# Rezoning Transportation Analysis

Petition Number: 2022-219

Date	Description
04-26-23	First Review (IW)
06-21-23	Second Review (DR)
07-25-23	Third Review ZC (IW)

RZ-1.0

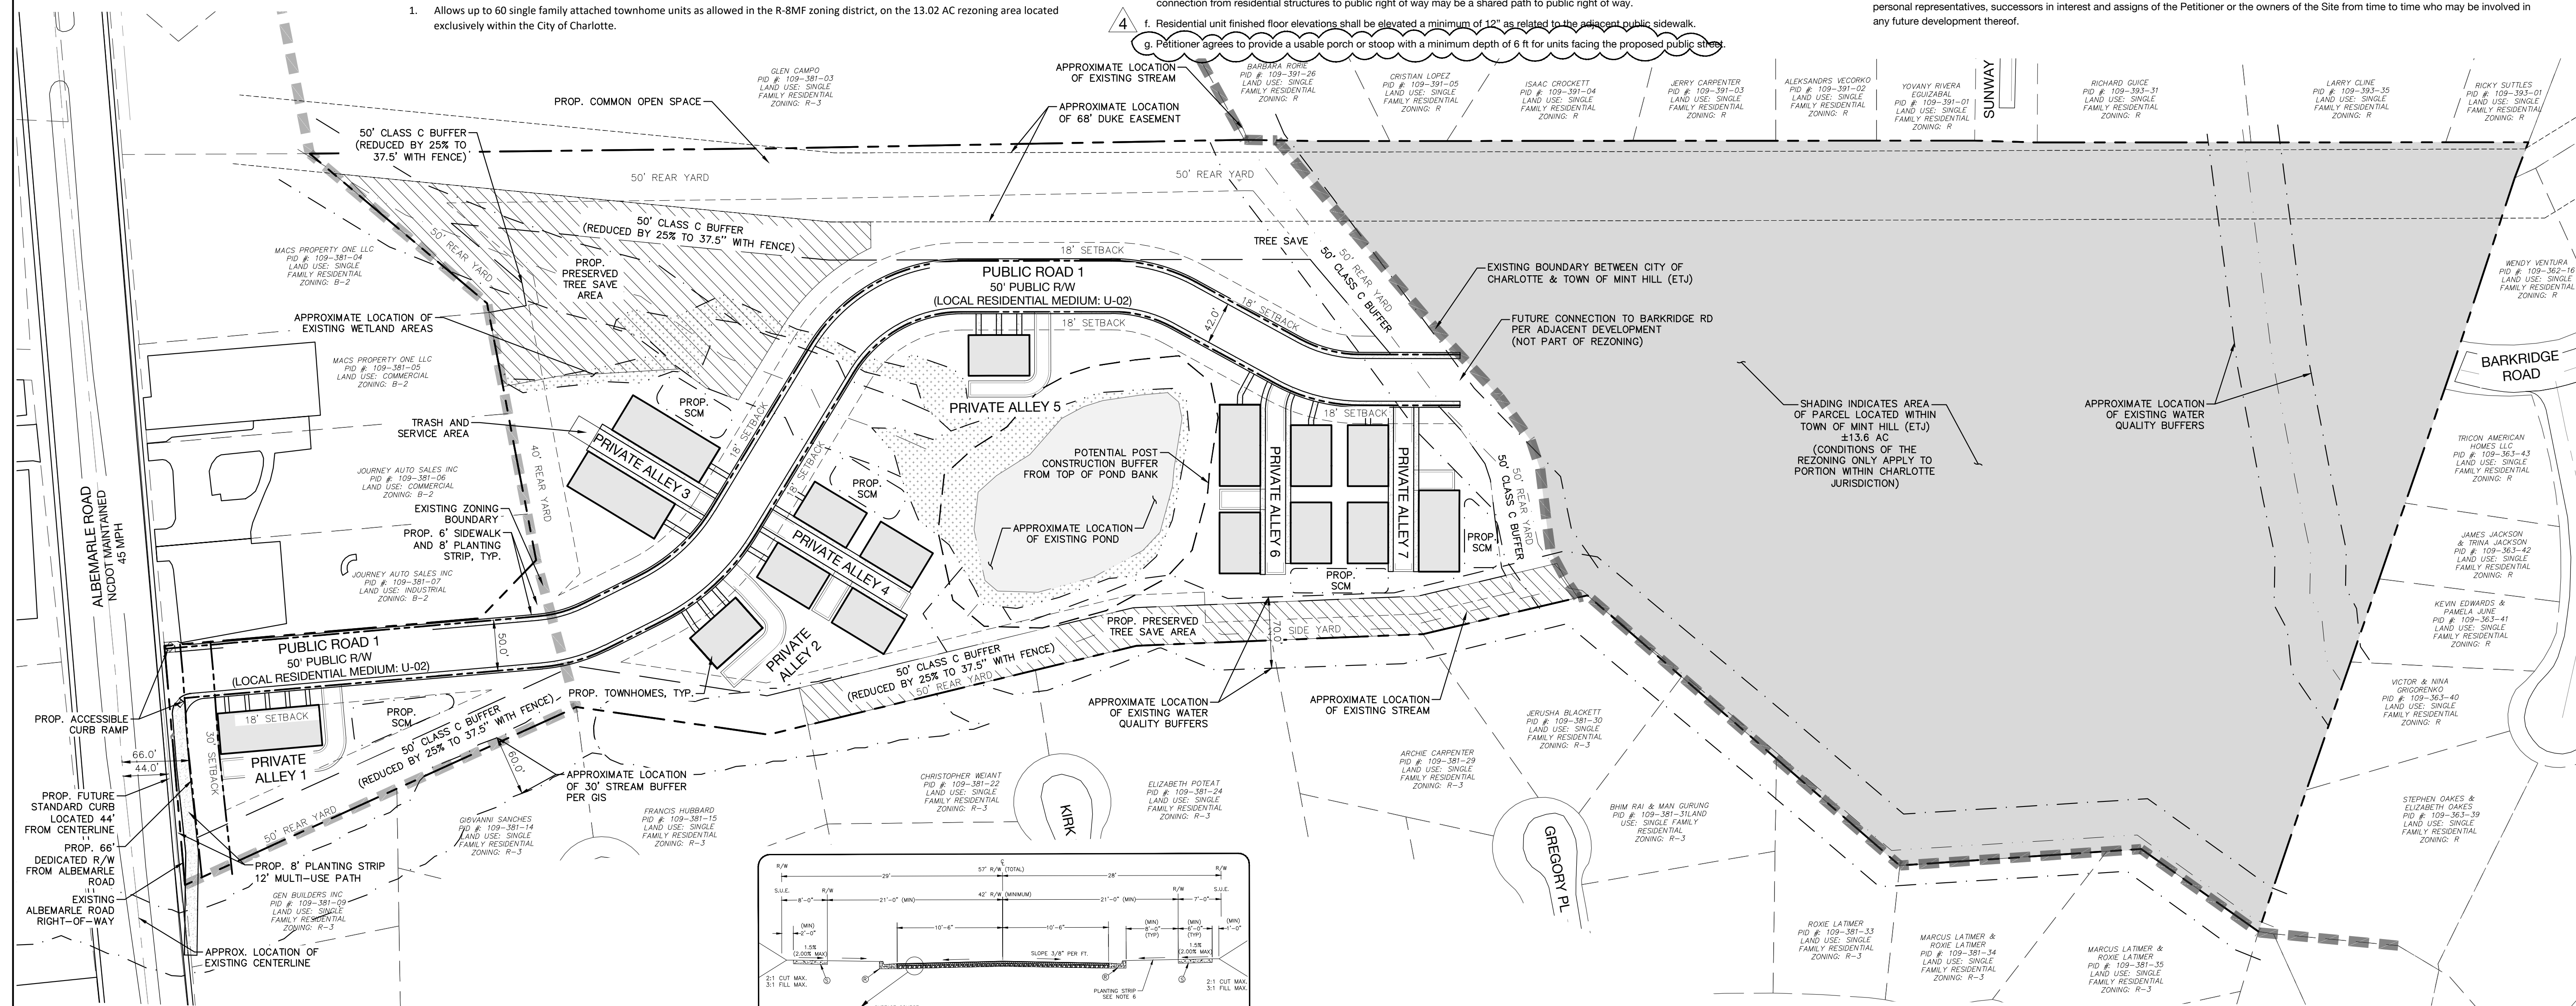
- a. ~~**Albemarle Road:** Location of curb and gutter to be moved to 44 feet from roadway centerline to accommodate the Charlotte Streets Map with a roadway typical section of 6+ Boulevard with shared use path.~~

~~Label and dimension the curb and gutter from the centerline for each road on the site plan.~~

- 3. ~~Revise site plan and conditional note(s) to commit to dedicate 66' right of way from the road centerline or 64' with a 2' SUE. The site plan shall label and dimension the right of way from the road centerline.~~

- 4. ~~Revise site plan and conditional note(s) to commit to constructing an 8-foot planting strip, and 6-foot sidewalk on Public Road 1 per Chapter 20. The site plan shall label and dimension both items from the back of curb and gutter or edge of pavement.~~

~~Conditional note 4 under "Transportation" states a 6' sidewalk and 8' planting strip will be provided as generally shown on site plan, but it is not clear on the site plan where this streetscape will be. Please clearly show planting strip and sidewalk will be along Public Road 1.~~

- ~~5. Revise site plan and conditional note(s) to commit to installing the 8' planting strip and 12' multi-use path at the future location to meet the Council-adopted Charlotte BIKES Policy and Charlotte. Multi-use paths maintained by the City shall meet ADA/PROWAG requirements.~~

- ~~7. Revise site plan and conditional note(s) to commit to create access on alley for townhomes currently proposed to have driveways on Public Road 1.~~

- ~~8. CDOT requests petitioner revise site plan and conditional note(s) to commit to constructing a right turn lane on Albemarle Road per coordination with NCDOT due to volume and speed in this area of the city.~~

**Clarifying comment from 6.21.2023:** In coordination with NCDOT, label and add a conditional note to constructing a right turn lane on Albemarle Road.

**Clarifying comment from 6.21.2023:** ~~Revise site plan and conditional to commit to constructing Public Road 1 to a Local Residential Wide Street Section (CLDSM U-03A).~~

- ~~10. Add a conditional note specifying “the Petitioner shall dedicate and convey in fee simple all rights of way to the City before the site’s first building certificate of occupancy is issued. CDOT requests rights-of-way set at 2’ behind back of sidewalk where feasible.”~~  
~~Update conditional note 5 under “Transportation” to have SUE 2’ behind MUP instead of 1’ as shown. 2’ is necessary for the maintenance of the path.~~

- ~~13. Revise site plan and conditional note(s) to better illustrate what conditional note 3 under “Transportation” is referencing. It states ADA ramps will be provided at the corner of Public Road 1 and Albemarle Road as illustrated but there is not illustration of this proposed improvement.~~

**Clarifying comment from 6.21.2023:** ~~Clearly show and label accessible curb ramps at the corner of Public Road 1 and Albemarle Road.~~
